Technical Note

Project No: ITB13091
Project Title: Ford Airfield – The Landings
Title: Sustainable Accessibility Addendum Note
Ref: 13091-029
Date: 5 August 2020

B	29.10.20	JD	RSA COMMENTS INCORP'D	DS	DS
A	16.07.20	JD	FOOTWAYS AMENDED	DS	DS
REV	DATE	BY	DESCRIPTION	CHK	APD
STATUS: DRAFT					
SCALE @ A3: 1:500		CHECKED: DS		APPROVED: DS	
FILE REF: ITB13091		DRAWN: SH		DATE: 17.07.18	
DRAWING No: ITB13091-GA-006					
PROJECT No: ITB13091				REV: B

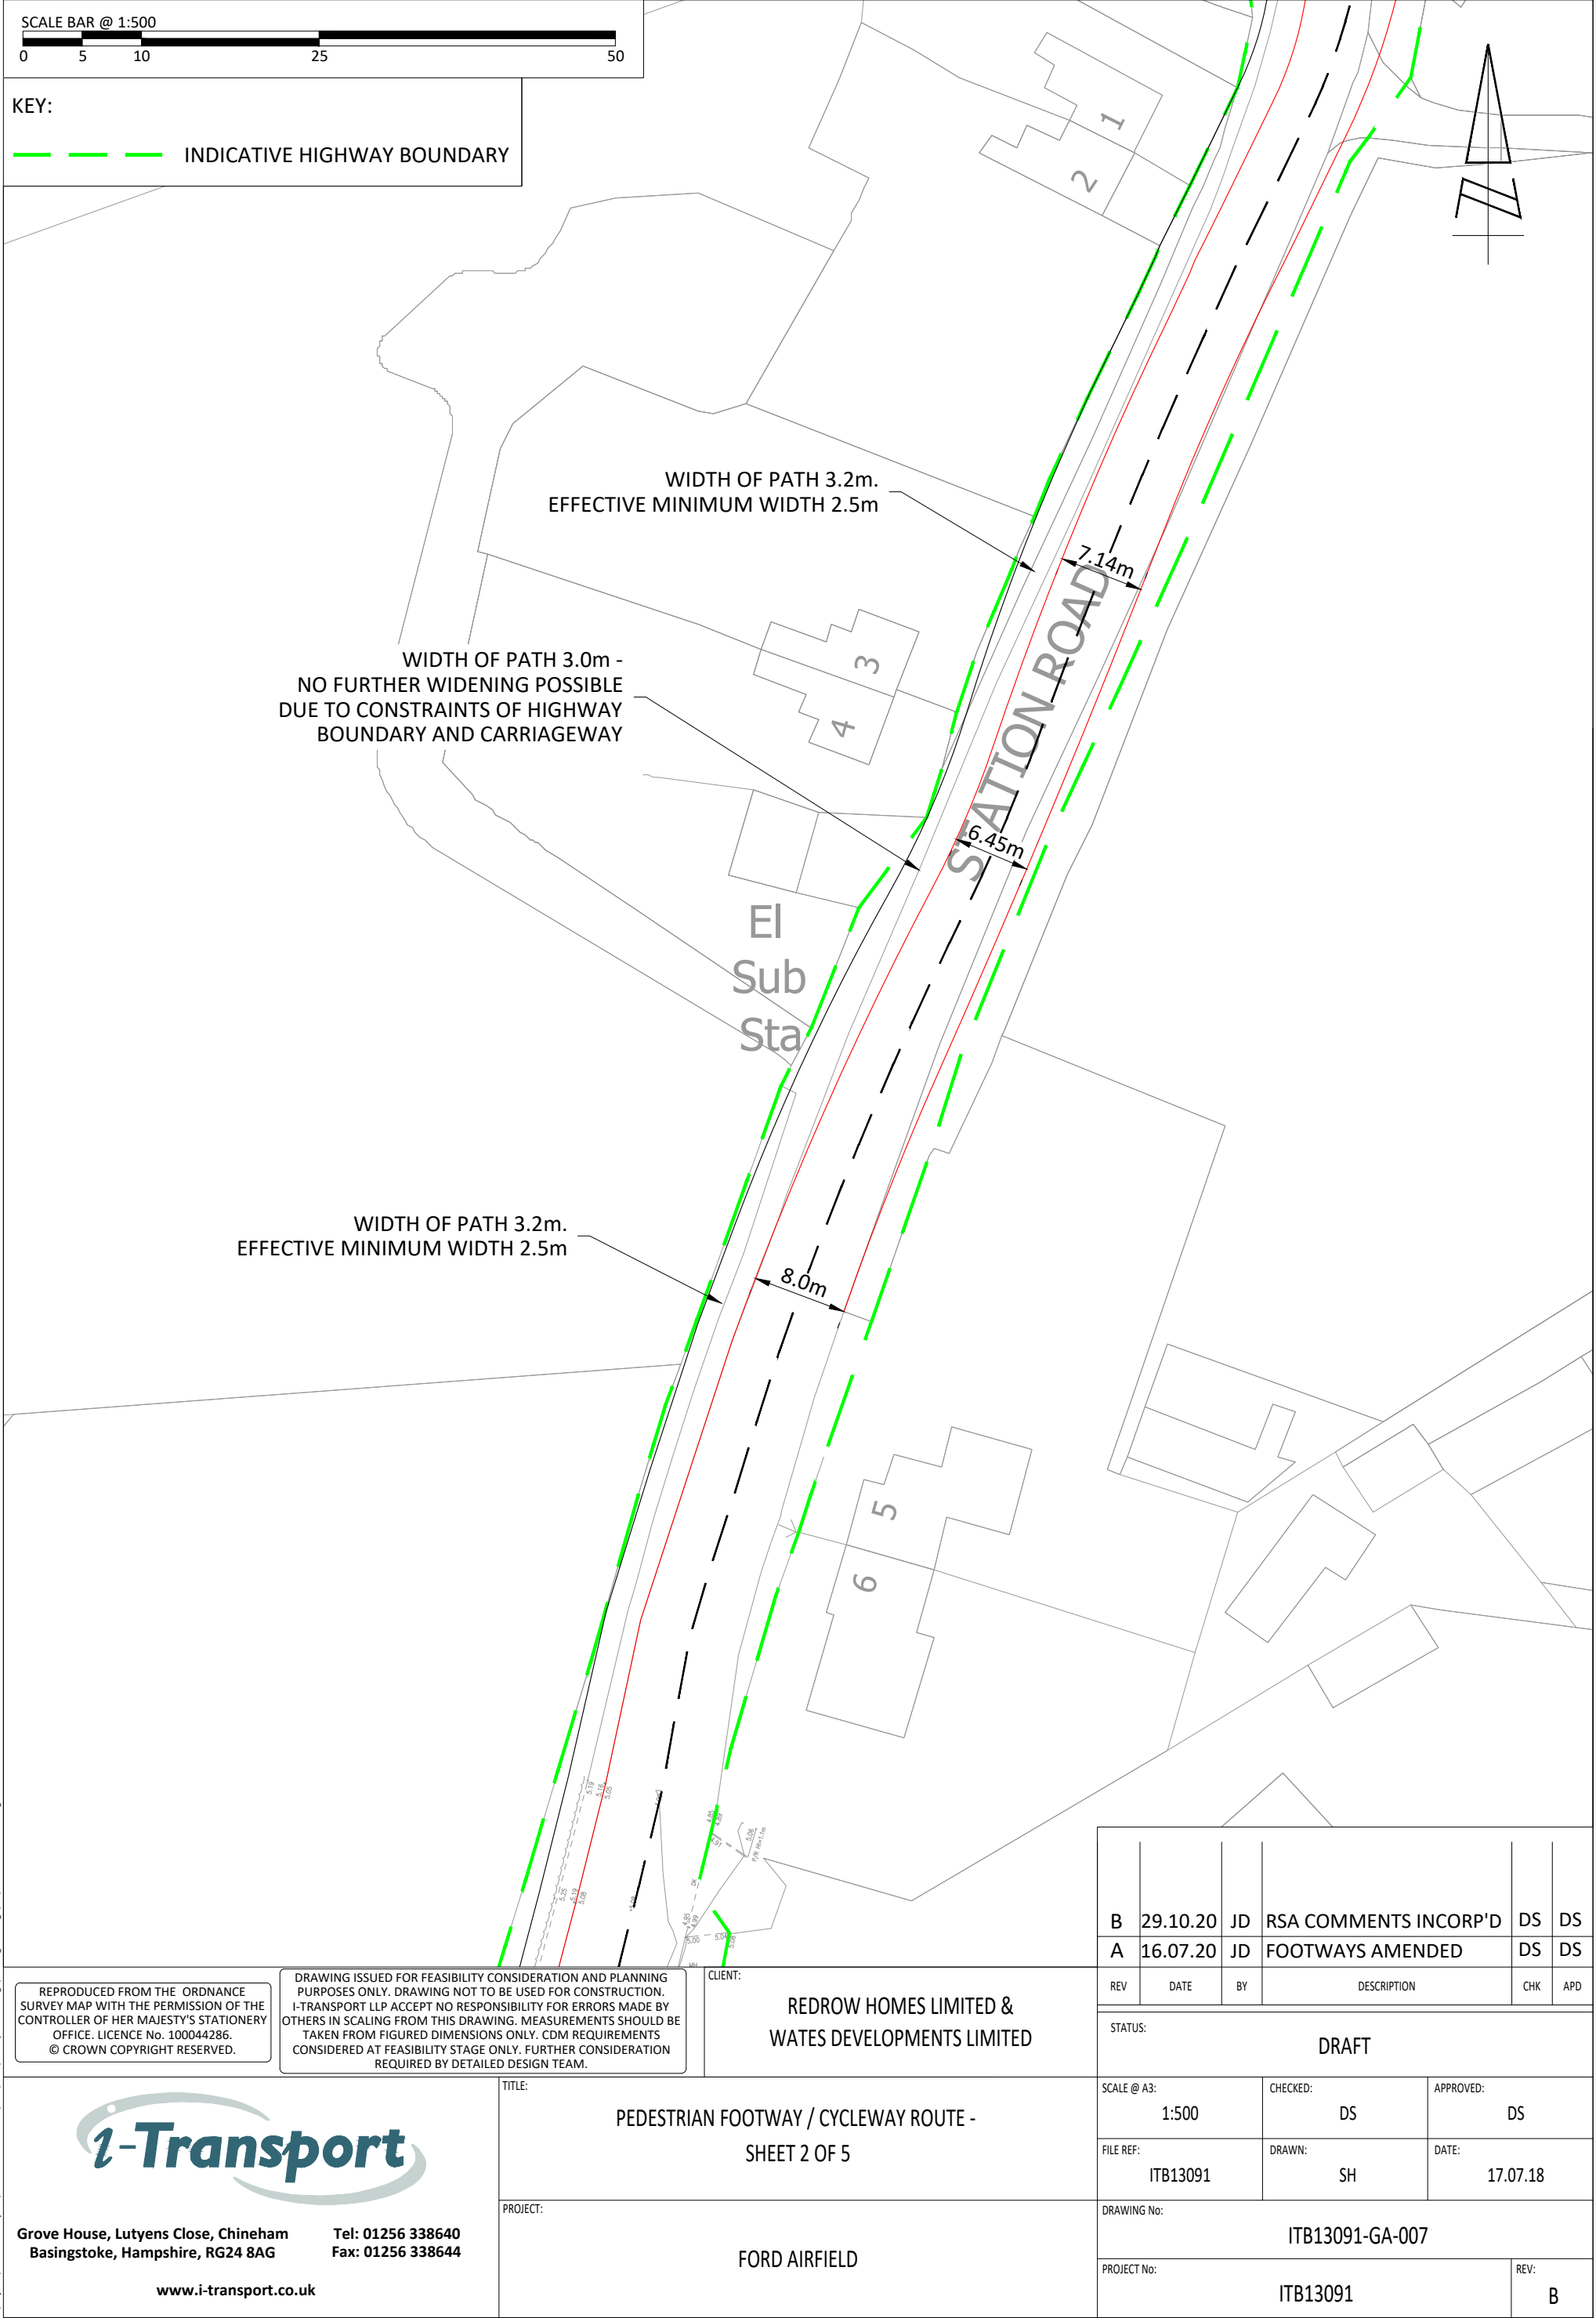
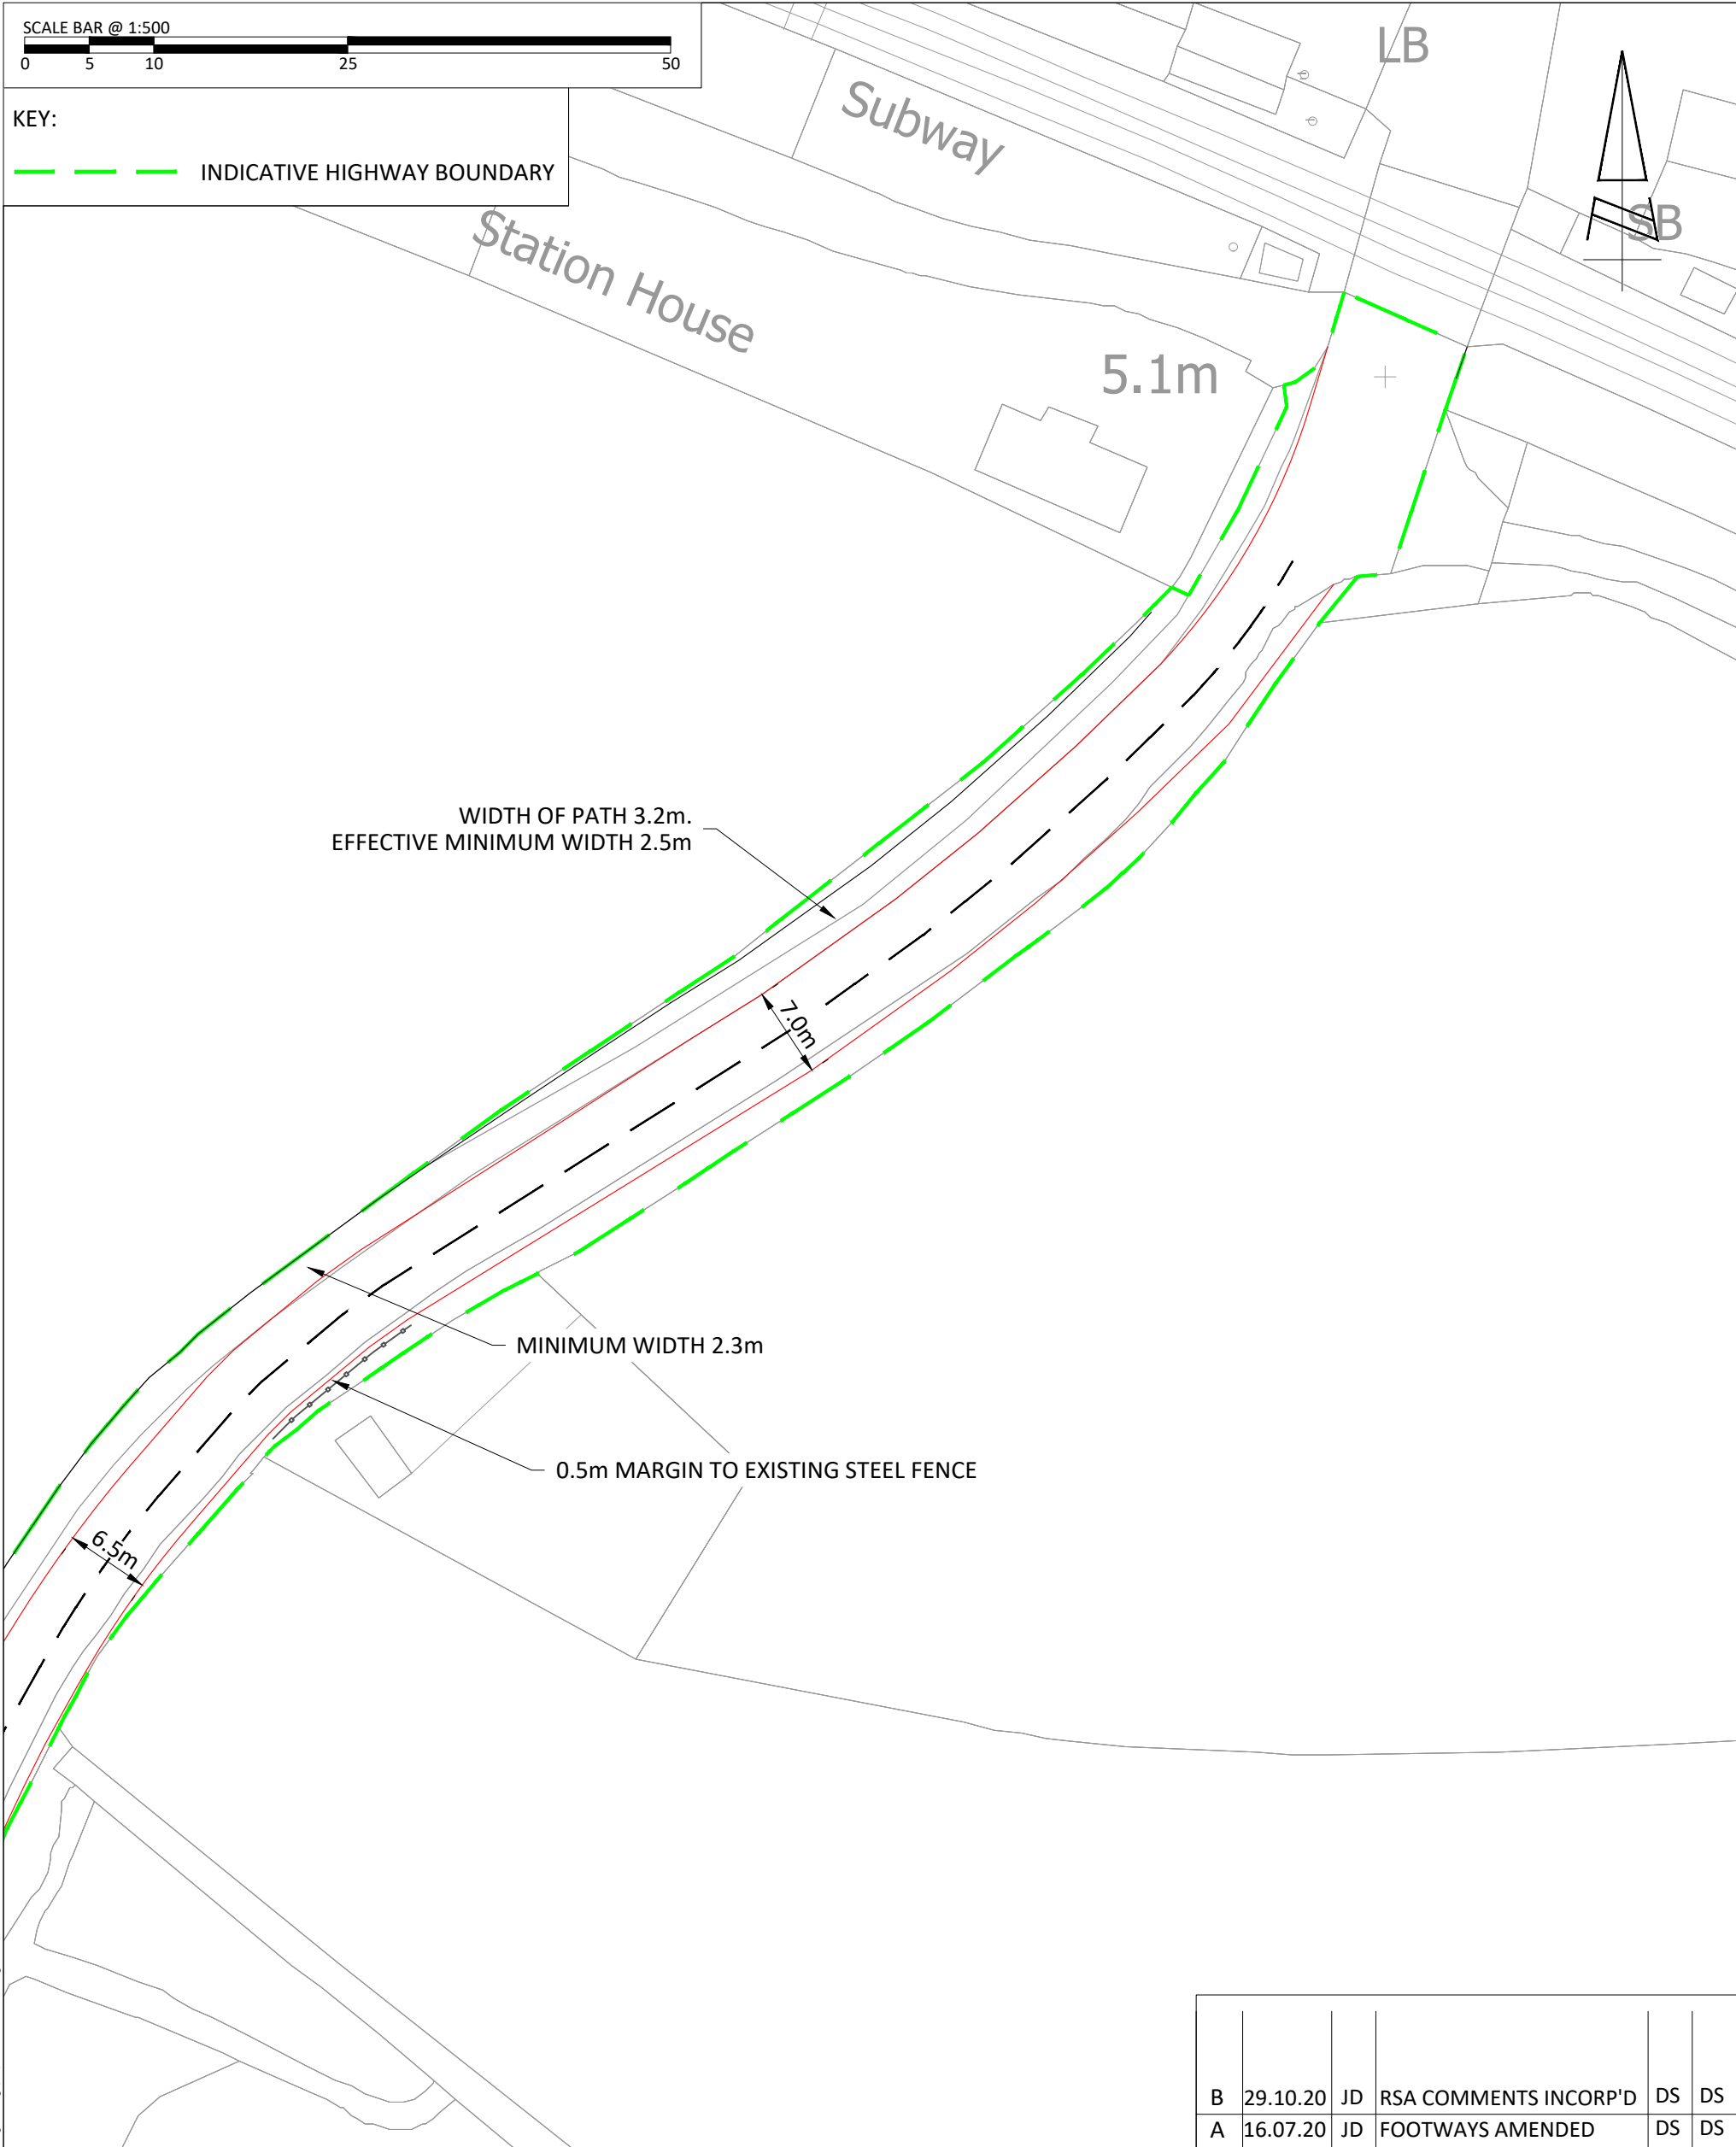
- 3.6.3 Notwithstanding, the scheme of works identified within the original assessment has been reviewed in the context of the CDG. Given the need to retrofit an improvement scheme within the constraints of the existing highway, it is not possible to provide a route that is fully compliant with the guidance. As identified in the guidance, where it is not possible to do this then the provision should be considered on a site-specific basis.

- 3.6.4 The identified scheme of improvements has been reviewed to allow for additional widening where possible. At locations where the route does not have a vertical obstruction on the eastern side of the highway boundary, an effective minimum width of 3.0m has been achieved by providing for an additional 200mm widening, achieved by offsetting the carriageway to the east of its existing alignment, or narrowing the carriage marginally (while maintaining a road width of a minimum of 6.8m). Where a vertical obstruction is present (e.g. a boundary wall or vegetation) the effective width reduces to 2.5m.

- 3.6.5 The revised scheme of improvements is presented in Drawings **ITB13091-GA-006 Rev A – ITB13091-GA-010 Rev A**.
